# CITY OF ALBUQUERQUE

February 27, 2019

RE: **Durango Subdivision, Units 3 - 5**  
**Tr H, Durango Unit 1 & Tr A Durango Unit 3A**  
**Drainage Report Stamp Date: 3/5/15**  
**Unit 3 Grading Plan Stamp Date: 8/12/15 (previously approved for Plat, 8/18/15)**  
**Unit 3A Grading Plan Stamp Date: 2/15/19**  
**Unit 4 Grading Plan Stamp Date: 8/12/15 (previously approved for Grading & Plat, 8/18/15)**  
**Unit 5 Grading Plan Stamp Date: 2/15/19**  
**Hydrology File: C09D012**

Based on the submittal received on 2/15/19 the above-referenced Grading Plans cannot be approved for Preliminary Plat, Grading Permit, and Work Order until the following are corrected:

CITY OF ALBUQUERQUE PUBLIC WORKS DEPARTMENT			
DURANGO			
UNIT 5			
GRADING AND DRAINAGE PLAN			
Design Review Committee	City Engineer Approval	Mo./Day/Yr.	Mo./Day/Yr.
City Project No.	Zone Map No.	Sheet	Of
	C-09-Z	2	4

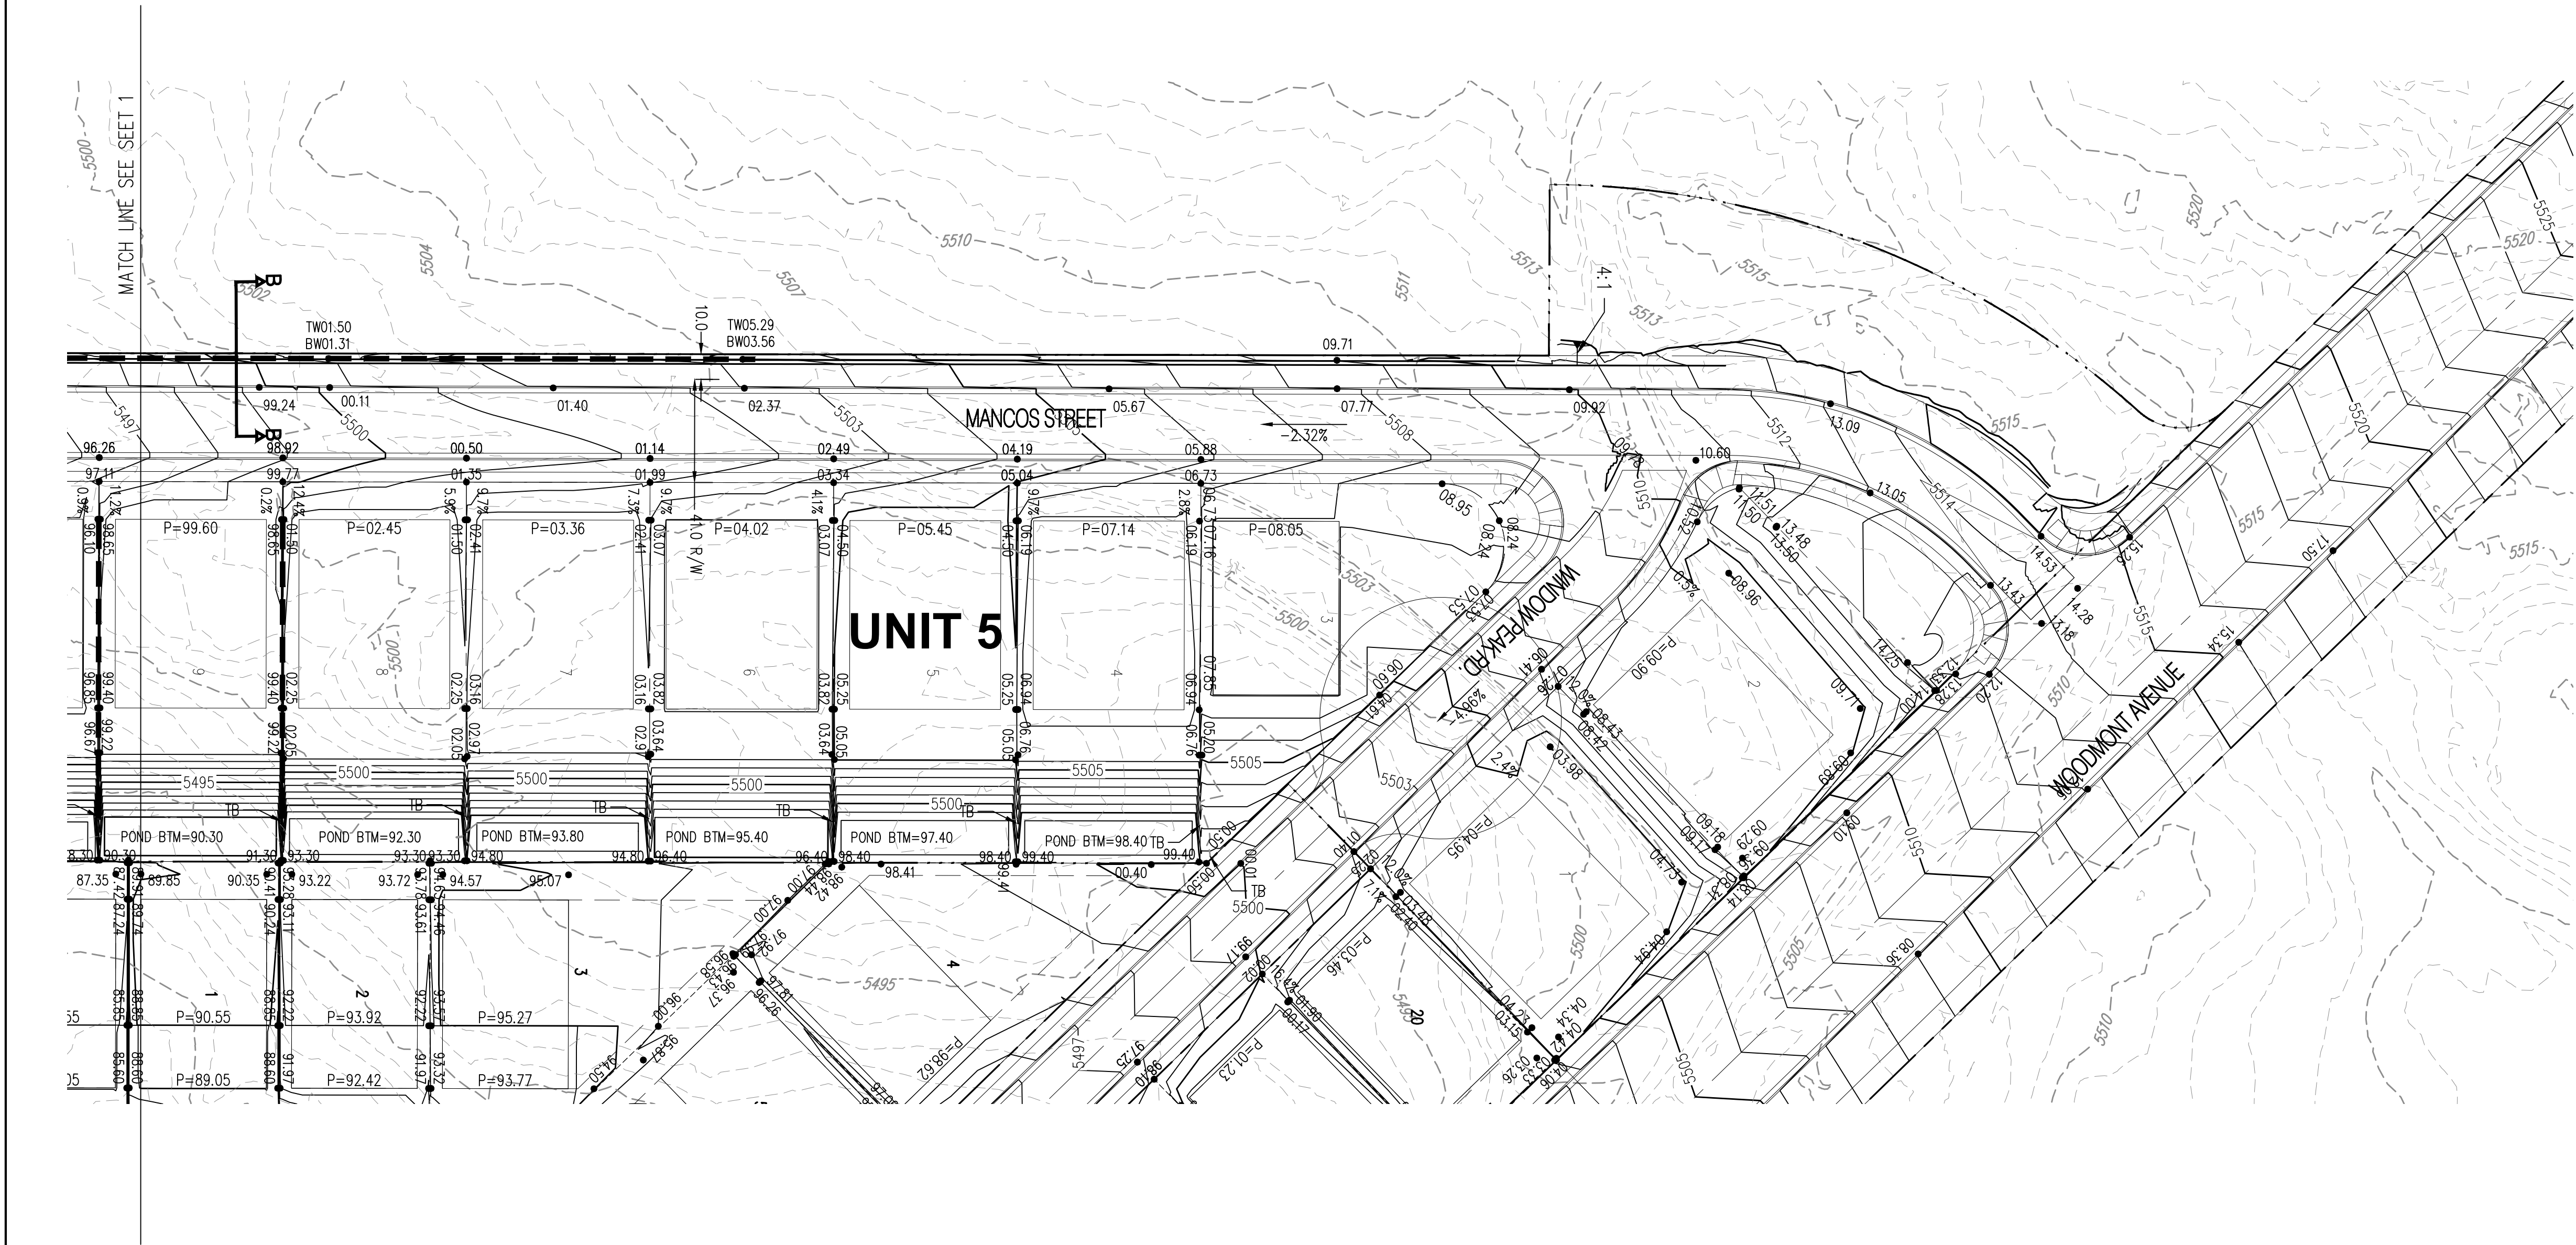
3. Along all external boundaries, provide sections of the proposed retaining walls and show the property line, existing and proposed grades on the section views. In accordance with DPM Ch.22, section 5 part B, grading and wall construction near the property line may not endanger adjacent property or constrain its use. Ensure that the retaining walls (including footers) do not encroach on neighboring property or public ROW. Sections are missing behind lots 1-2 (backing up to Woodmont) and behind lots 18-19 (backing up to SLO land). If a revocable permit is pursued it should be discussed prior to Preliminary Plat, so it can be included as an infrastructure list item.

4. Tract C needs to be eliminated and made part of Lot18, with a public drainage easement placed over the drainage swale. The drainage swale needs to be concrete (Std Dwg 2260) and

listed on the Infrastructure List, as it will be publically maintained. This swale needs to be sized for the area draining to it, including sediment bulking and sediment transport capacity. Flow from the Open Space needs to be conveyed through the swale to Mancos; it cannot be diverted south the SLO tract and towards the APS school. How will flows be conveyed to Mancos across the sidewalk? Transportation has indicated that a dip section will be acceptable here.
